From:
Sent: 25 March 2024 09:55
To: DCAdmin
Subject: Planning Application No. 2024/90339

19 Cheviot Way, Upper Hopton, Mirfield, WF14 8HW

I am writing to express my concerns over aspects of the above planning application for extensions at 19 Cheviot Way, Upper Hopton.

PROPOSED BLOCK PLAN
1:500

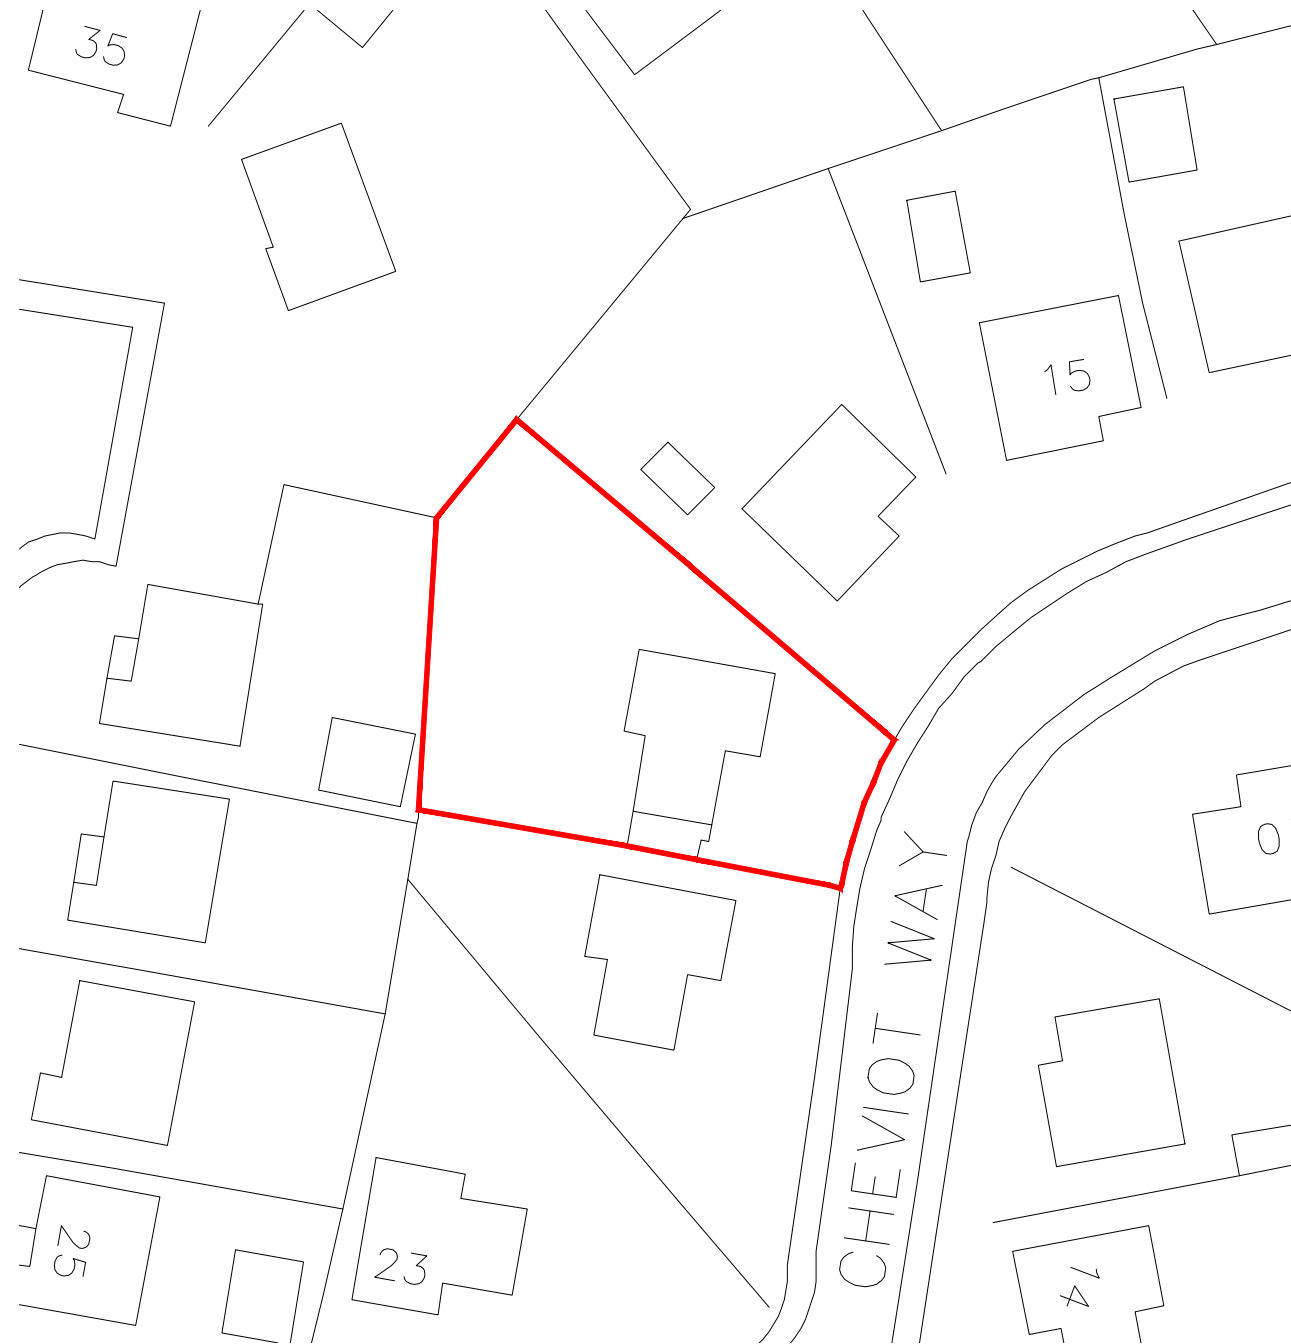
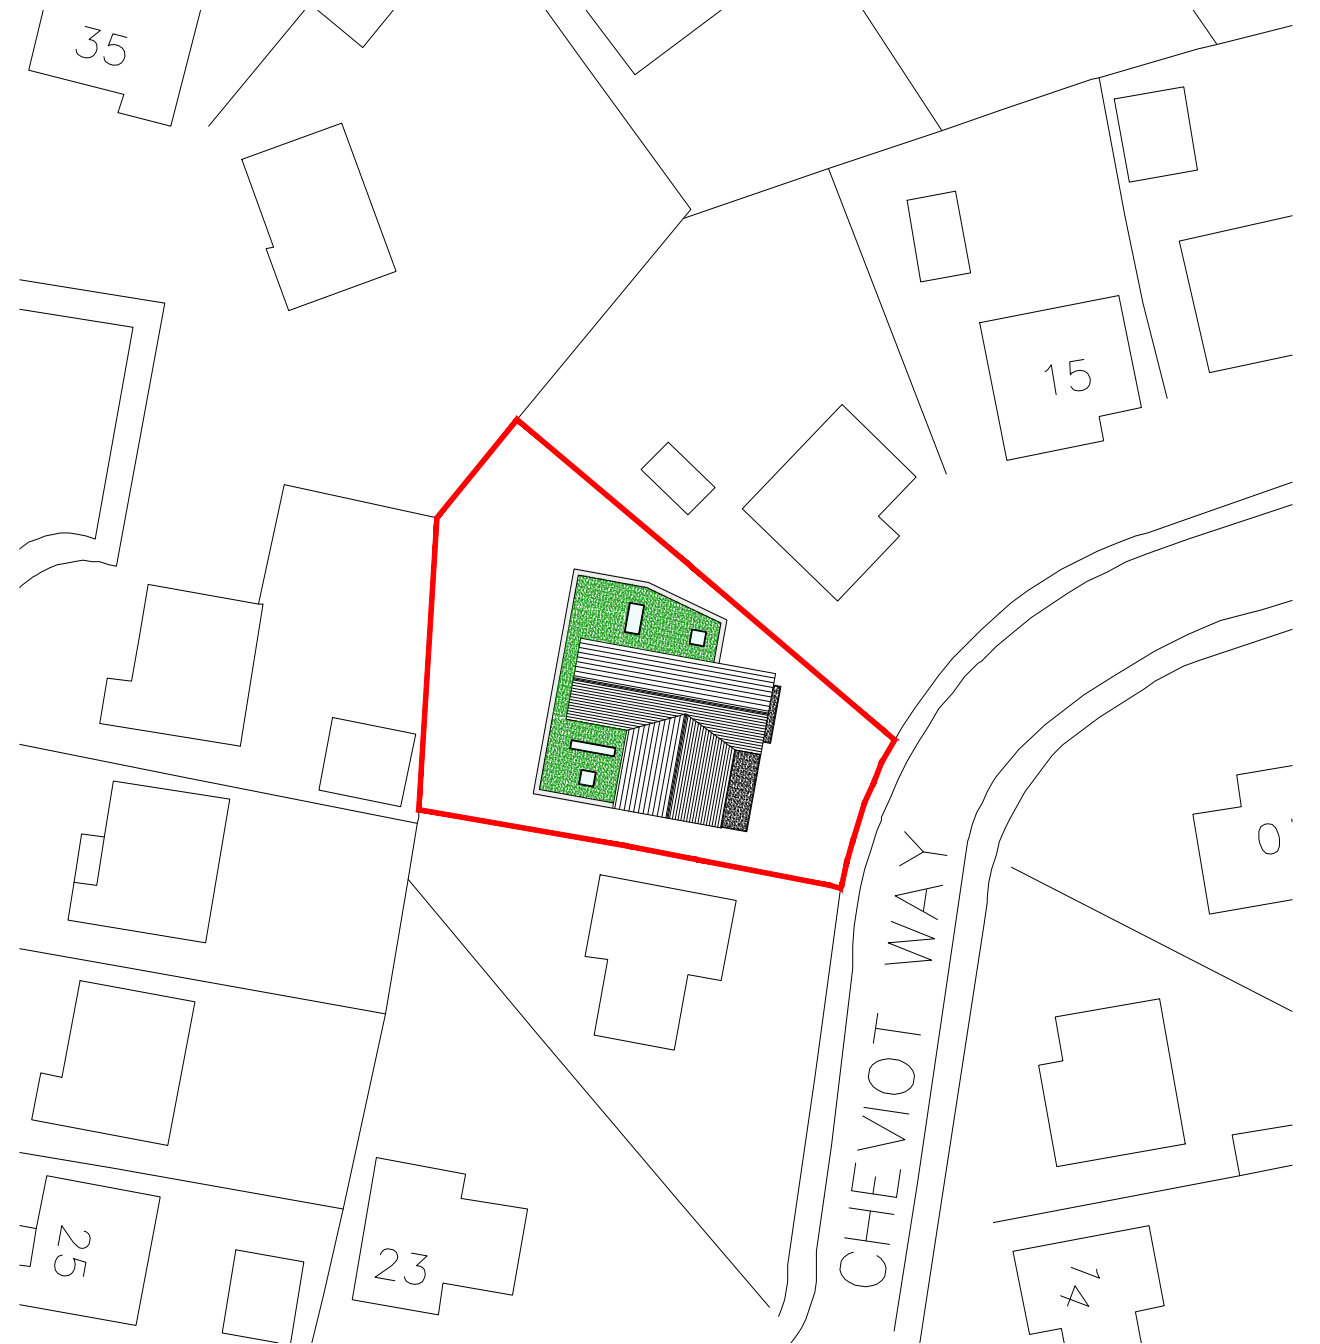
The Block Plan, which is incorrect, gives the impression that there is a view between the existing houses but it does not show the new house at 33a .

The omission of the new house should be added to the Block Plan before this proposal is given any further consideration.
